**Ann Machado - 135 Congress St. - Permit #2013-02268 - Legalization of nonconforming dwelling unit.**

**From:** Ann Machado  
**To:** William Simpson  
**Date:** 10/9/2013 3:03 PM  
**Subject:** 135 Congress St. - Permit #2013-02268 - Legalization of nonconforming dwelling unit.

SHEET TITLE:
SECOND FLOOR PLAN

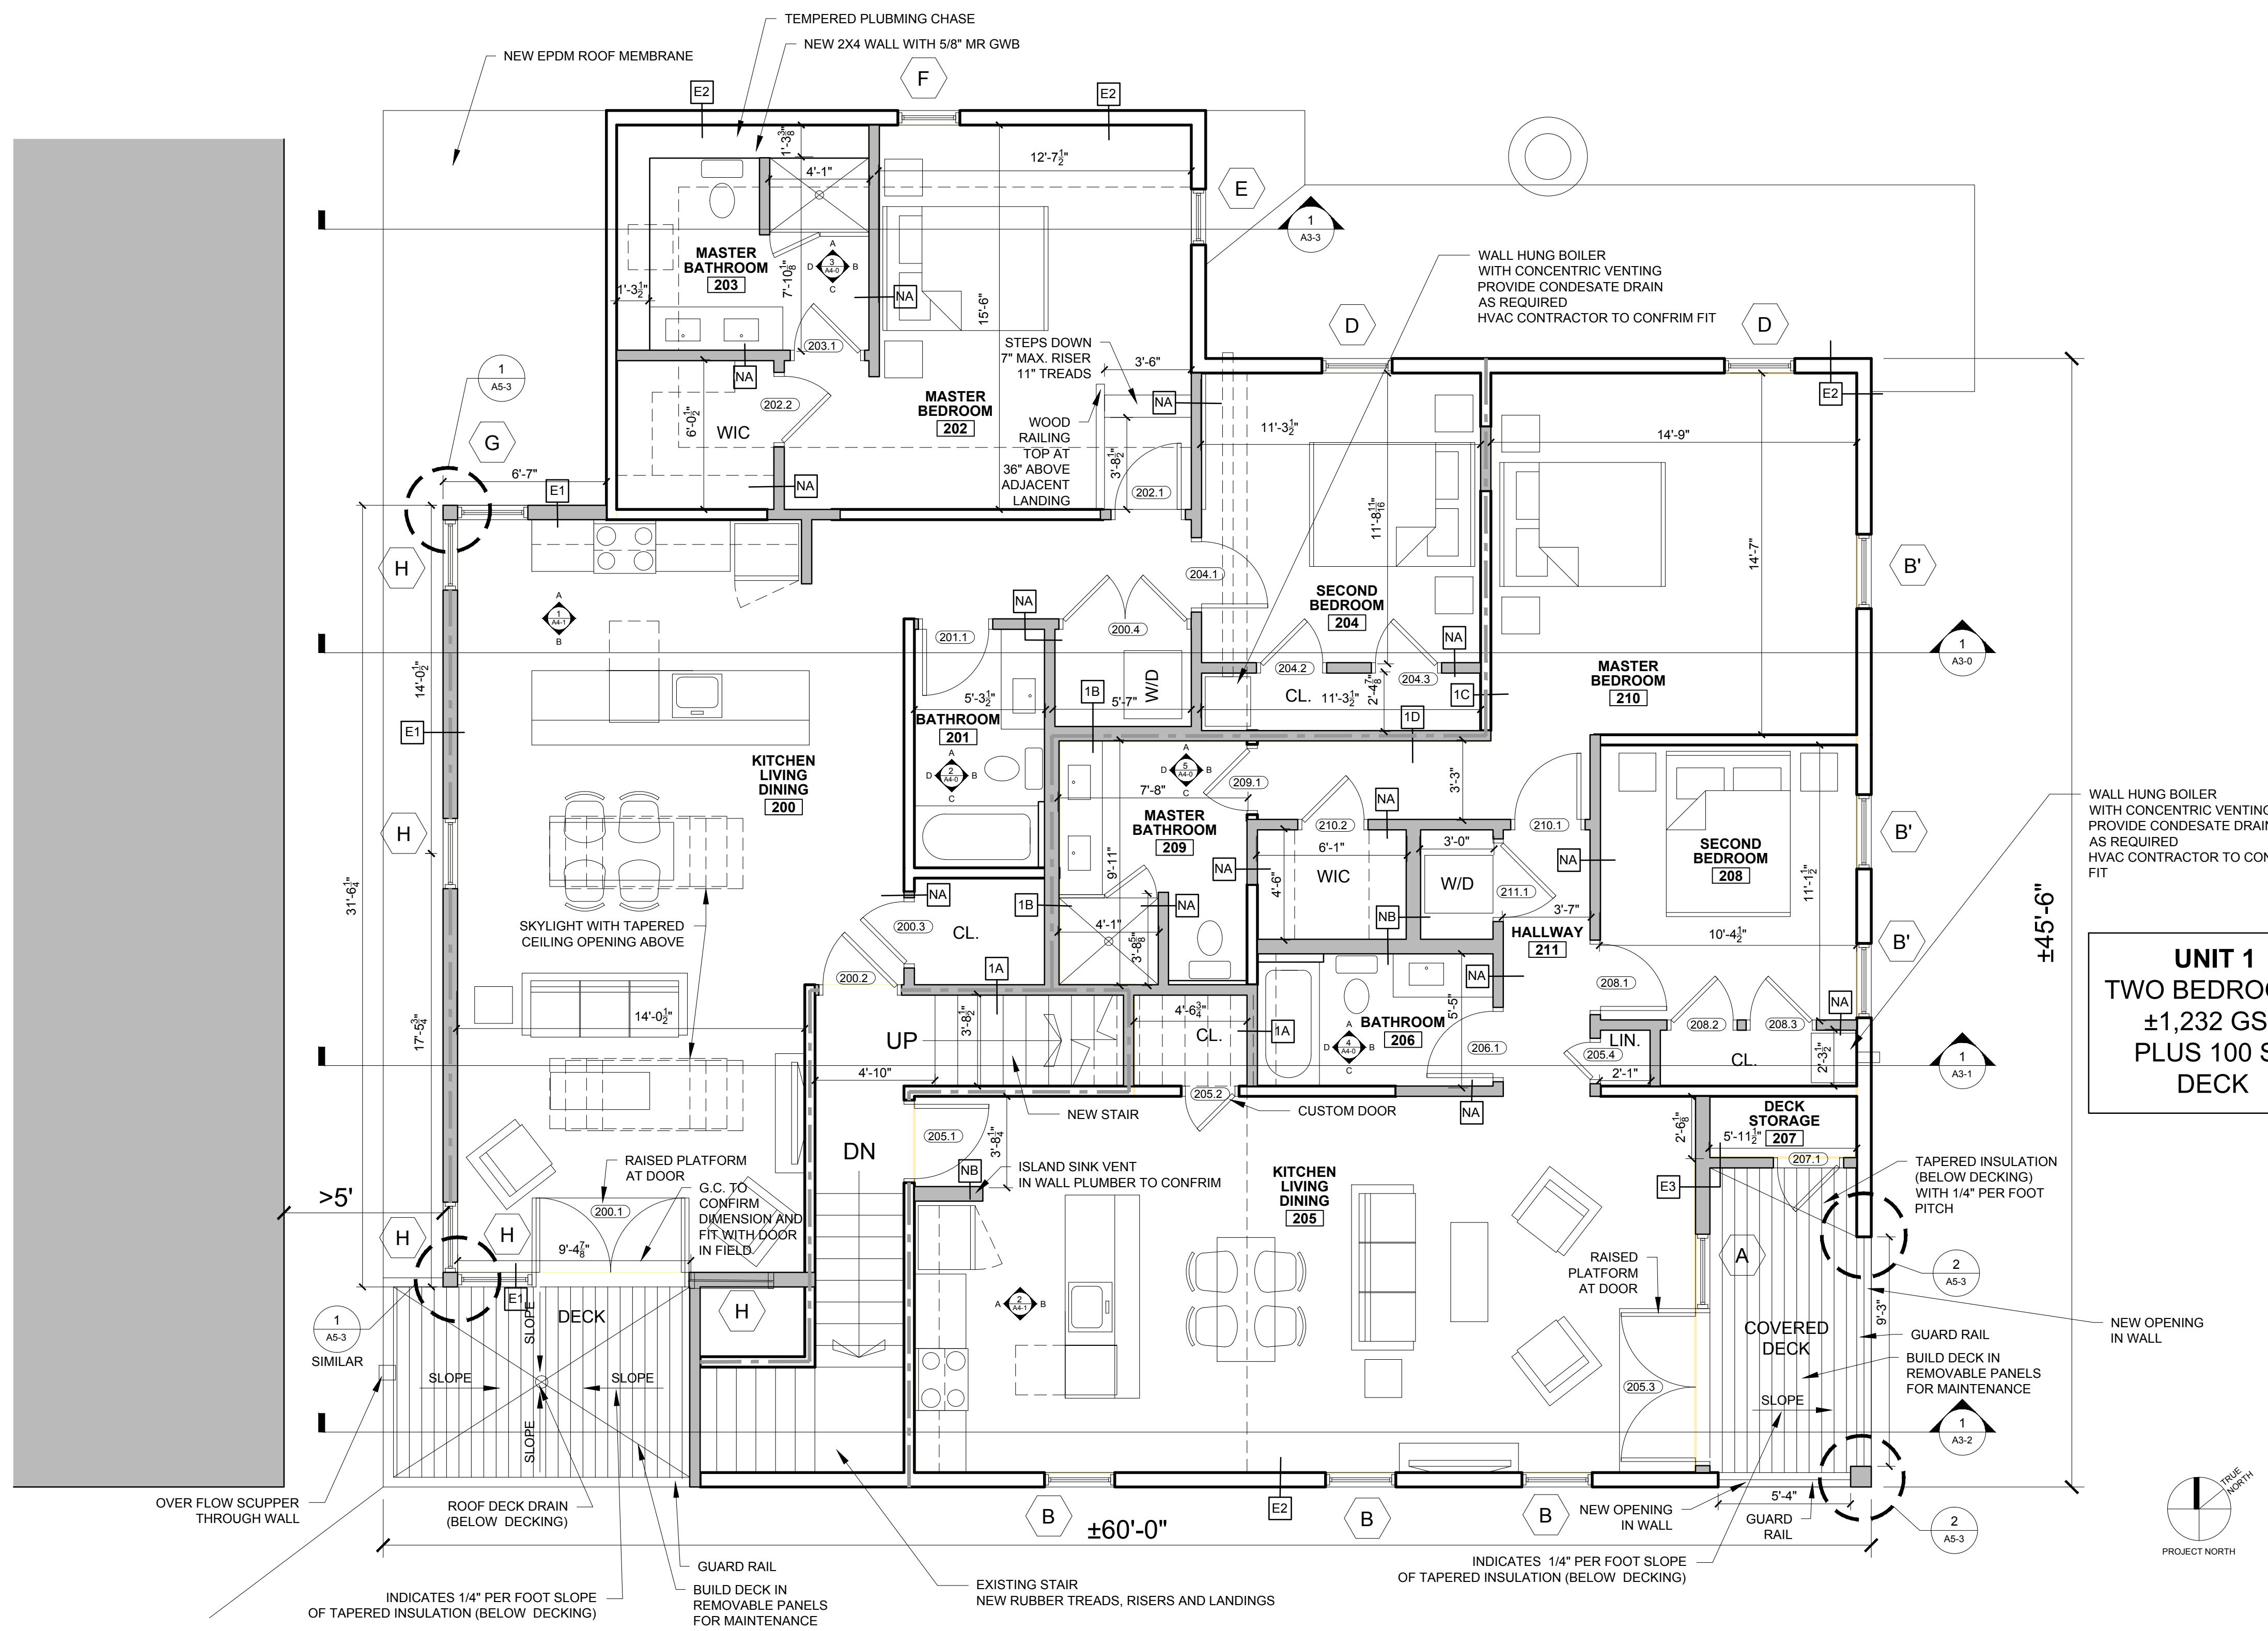
The floor plans that were provided with the permit are for the proposed renovations/alterations to the second and third floor under permit #2013-01923. They do not show the existing conditions. Part of the process to be able to legalize a nonconforming dwelling unit is that the building has to meet the Housing Code and the Life Safety Code. I don't know if the building in its present state can do that. It may depend on the work proposed for the second & third floor under permit #2013-01923 be completed and then the legalization could be approved.
